From: Martyn White
Sent: 01 April 2019 11:37
To: Zac Denton
Cc: Planning.Responses
Subject: A/10/19/L

A/10/19/L

The application is for Listed Building Consent to create shower room with WC and sink on first floor. This will require the removal of a modern built in wardrobe, the erection of a stud wall in the second bedroom in order to create a new bathroom. A new door way is required from the hallway in order to provide access to the room.

Drawing No
116.P1

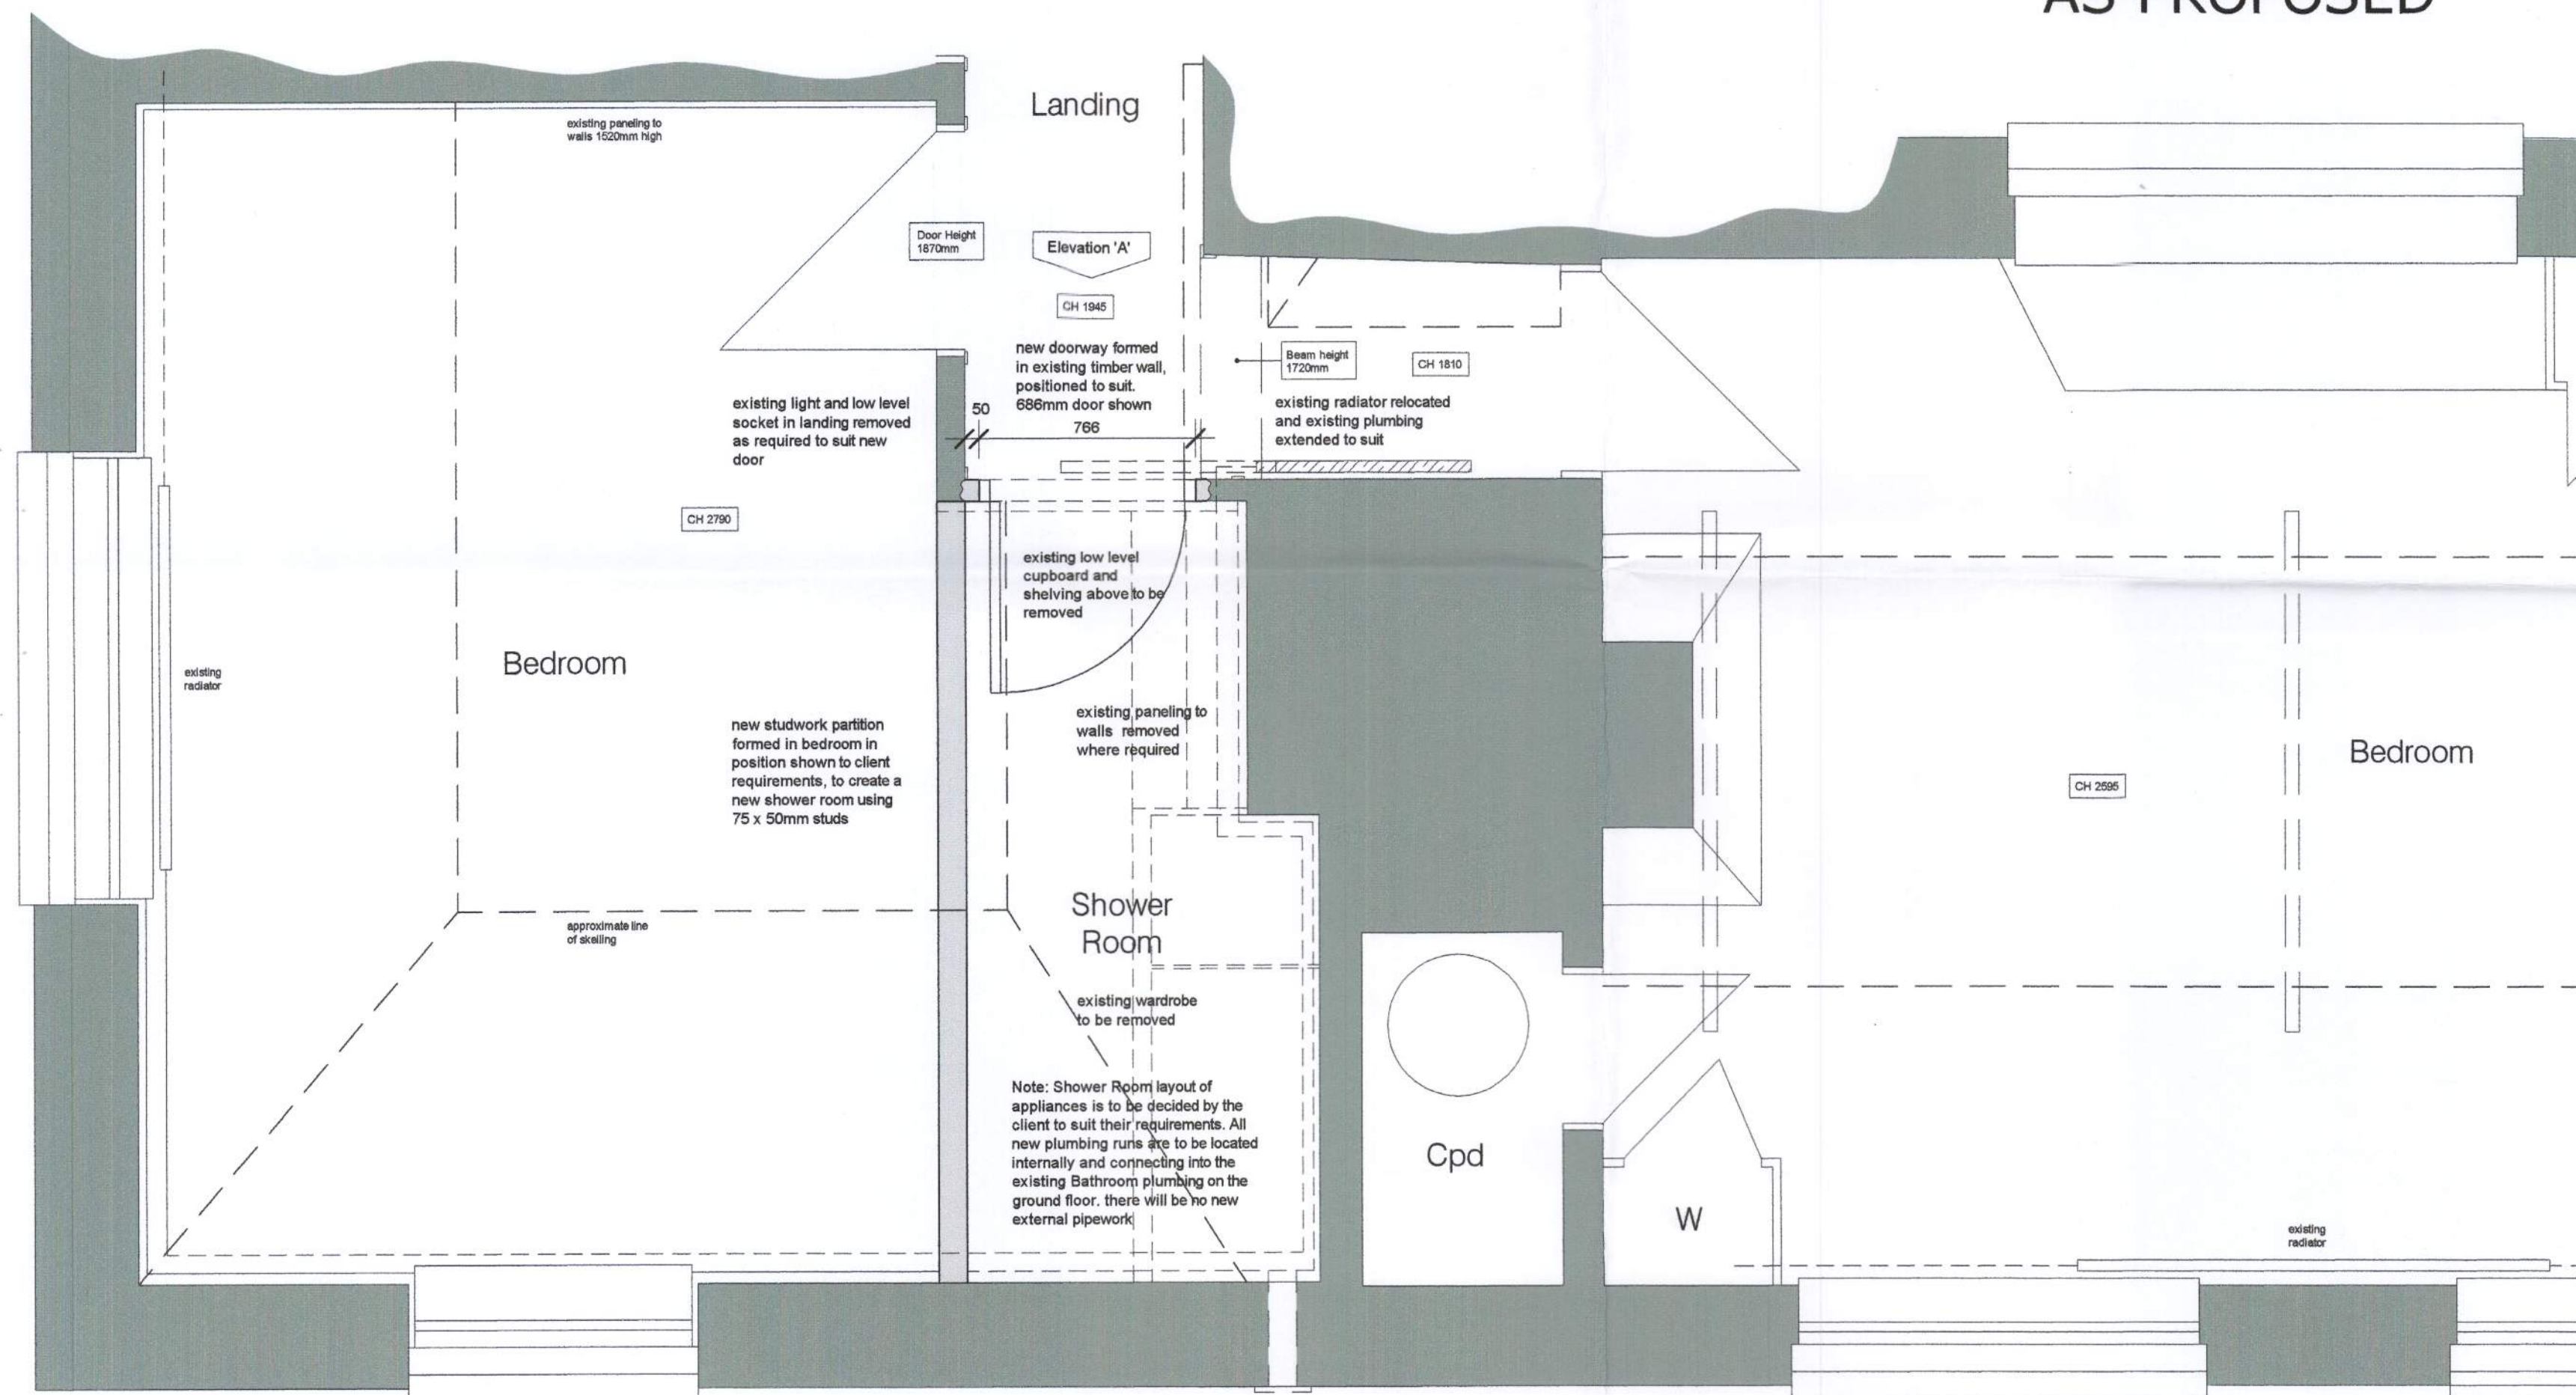
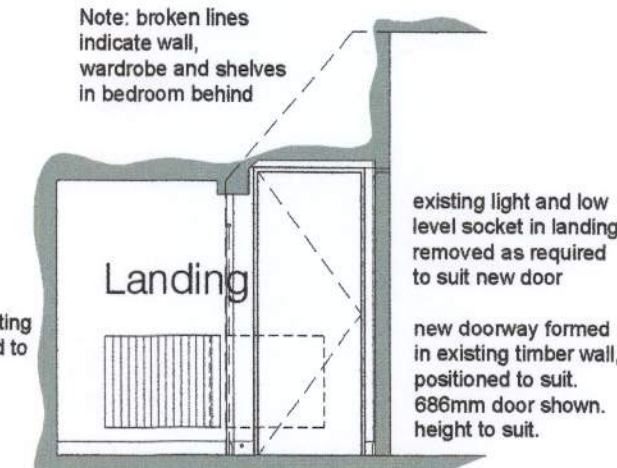
The proposal is to form a small shower room at first floor level with access off the landing. This will be achieved by subdividing one of the bedrooms, removing a modern built in modern wardrobe, shelving and unit, as well as making a new opening from the hallway.

I note that reference is made to the new door replicating the existing doors on the first floor. Such an approach is supported.

An extract fan is required which will be taken out through the external wall and terminating with a grille. It will be black in colour in order for it to blend in with the flint work. It is hoped that this will not be any bigger than required. You may wish to see details of the grille before it is installed in order to ensure that it reflects the character of the building.
